Rezoning Transportation Analysis

Petition Number: 2021-092

Date	Description
06-01-2021	First Review (KP)
08-23-2021	Second Review (KP)
10-22-2021	Third Review (KP)
11-22-2021	Fourth Review (KP)

Plotted By: Camille, Pat. Sheet: Sht. Atrium - C/C Rezoning. Layout: RZ-1.1. TYPICAL SECTIONS. November 18, 2021. 04:40:59pm. \\kimley-horn.com\SE_CHL\CHL_PRA_015031_Carolinas_Healthcare_System\128_C/C Rezoning and Design\02 - DWG\Plots\Sheets\1-0 - Rezoning_RZ-1.1_Technical_Data_Sheet.dwg

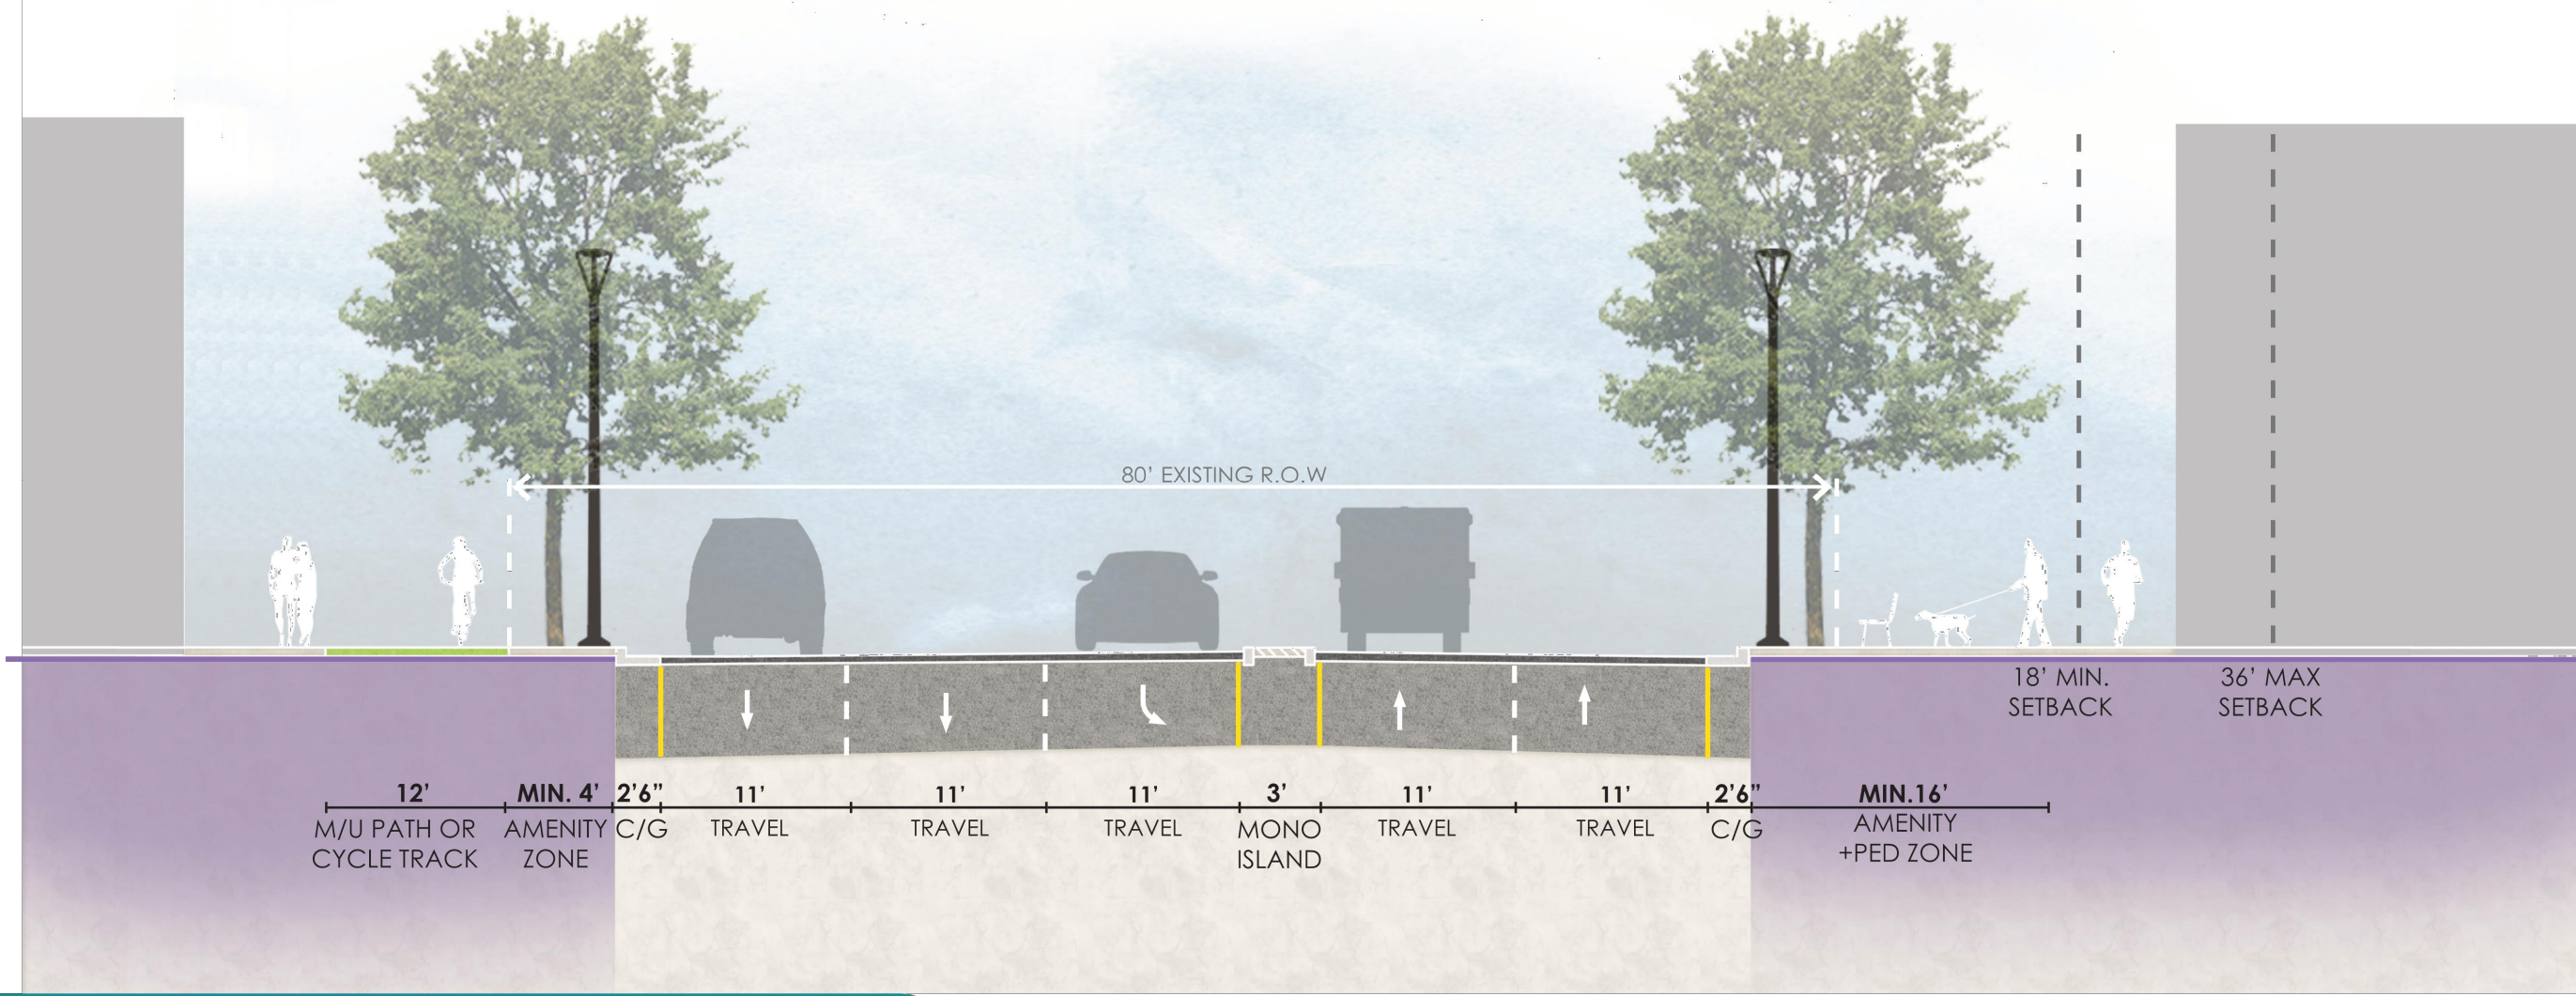
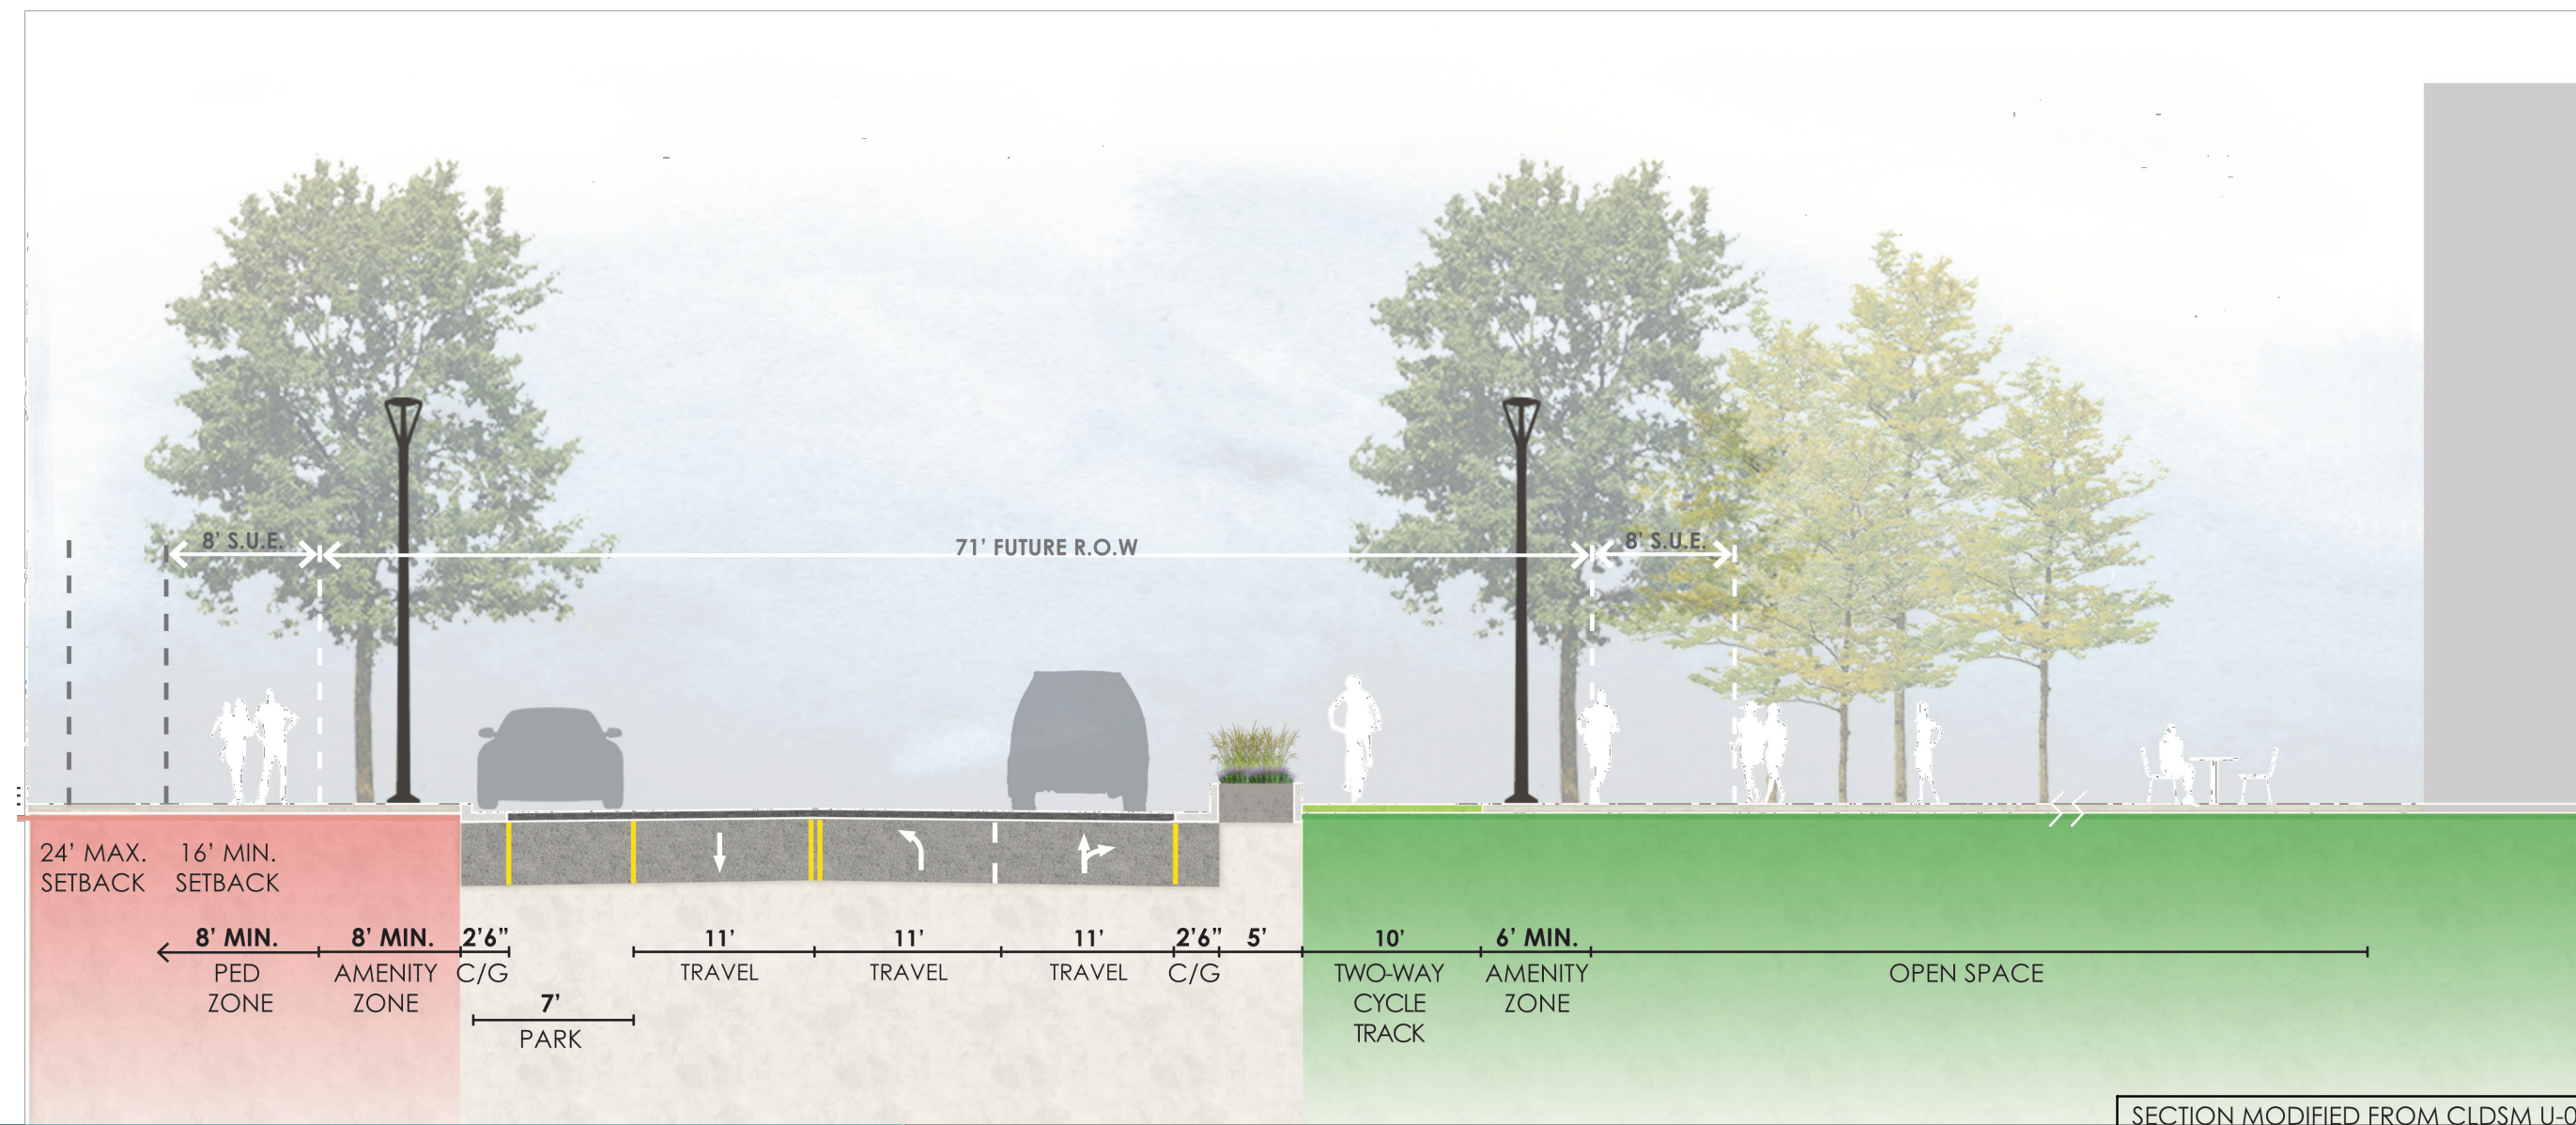
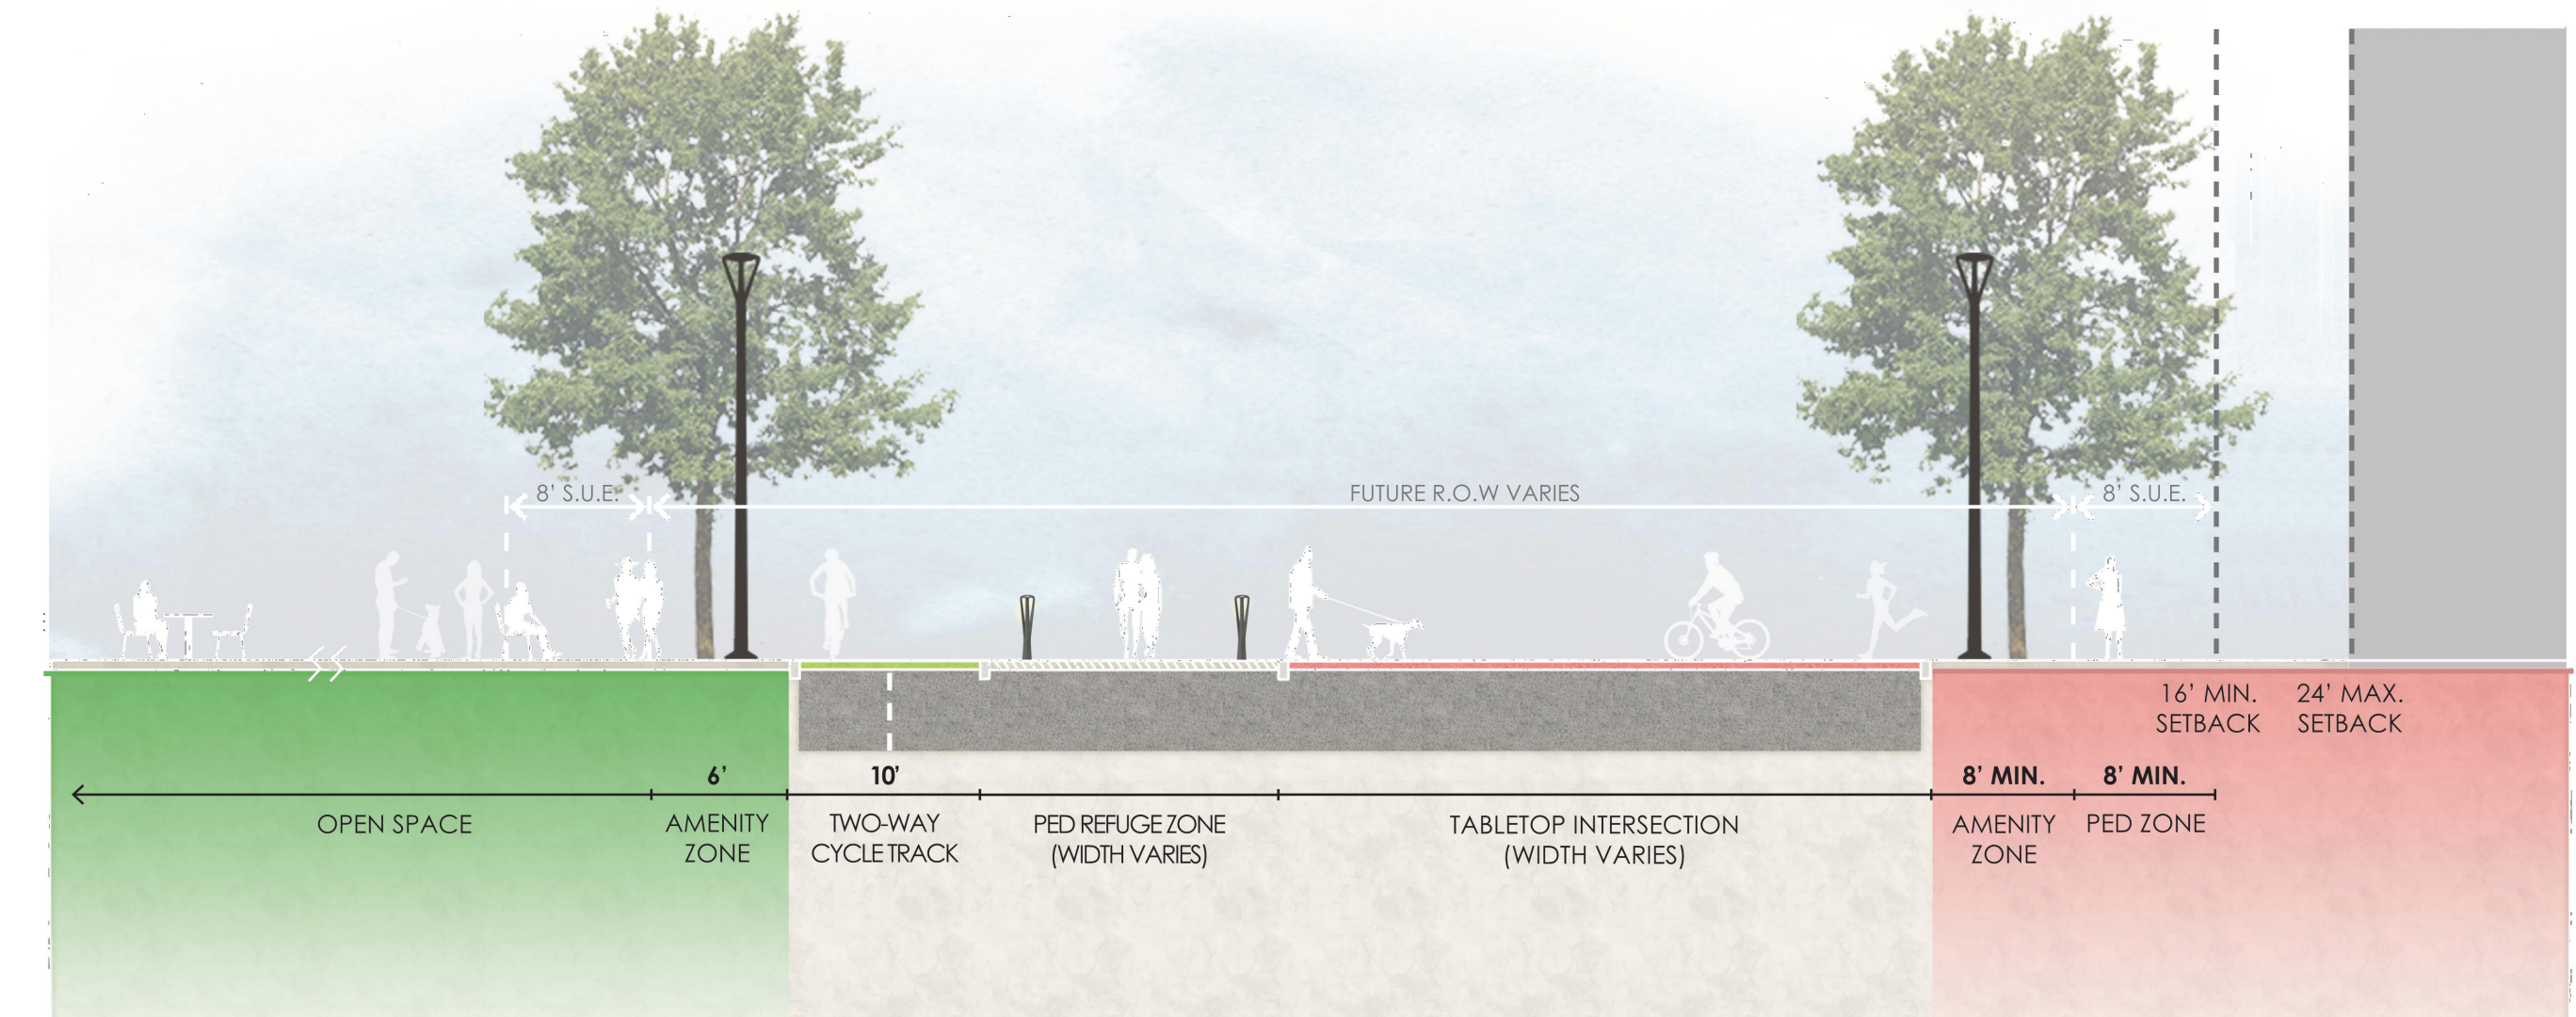
1. **Curb line:** The proposed zoning district has a setback measured from back of the existing or proposed future curb line. Revise Sheet RZ-1.1 by adding the curb line dimensions to the cross sections provided. Please note: The following curb line dimensions proposed are conceptual and may be altered as coordination with CDOT throughout the rezoning process ensues.

- a. ~~**Morehead Street:**~~ The location of curb and gutter will be moved and located 38 feet from the existing centerline to the back of curb. ~~(Revise Site Plan Dated: 10.12.21)~~ Update to comply with Chapter 20 sidewalk and planting strip requirements.

The proposed and existing back of curb location on Morehead Street must be labeled dimensioned from the existing centerline.

3. **Right of way and Other Infrastructure Dimensions:** Revise Rezoning Sheet RZ-1.1 to include detailed dimensions for each infrastructure item, and the total right of way for the cross sections shown. Refer to the USDG Cross sections and on street parking details, located within the Charlotte Land Development Standards Manual, to determine the appropriate widths associated with each infrastructure item and the cross sections' total widths. Revise the site plan sheets by clearly labeling each public and private street section as well as each access point. Labeling each street section and access point will allow for thorough comments throughout the rezoning and permitting process. CDOT prefers the separated cycle track and sidewalk for McDowell Street (cross sections A-A and B-B). Please note: The following right of way dimensions proposed are conceptual and may be altered as coordination with CDOT throughout the rezoning process ensues:

- a. ~~**Morehead Street: (10/21/2021 Site Plan)**~~ – 56 feet of right of way dedication measured from the existing road centerline.
- b. ~~**McDowell Street:**~~ 110 feet of total right of way dedication, 55 feet measured from the existing road centerline to each right of way line.

The proposed and existing Morehead Street right of way dedication must be labeled dimensioned from the existing centerline. ~~**Outstanding comment (10/21/2021 Site Plan)**~~ – Revise the site plan conditional notes and legends that all new streets shall be determined as public or private during permitting. Revise cycle track along McDowell Street to include a sidewalk utility easement, where appropriate.
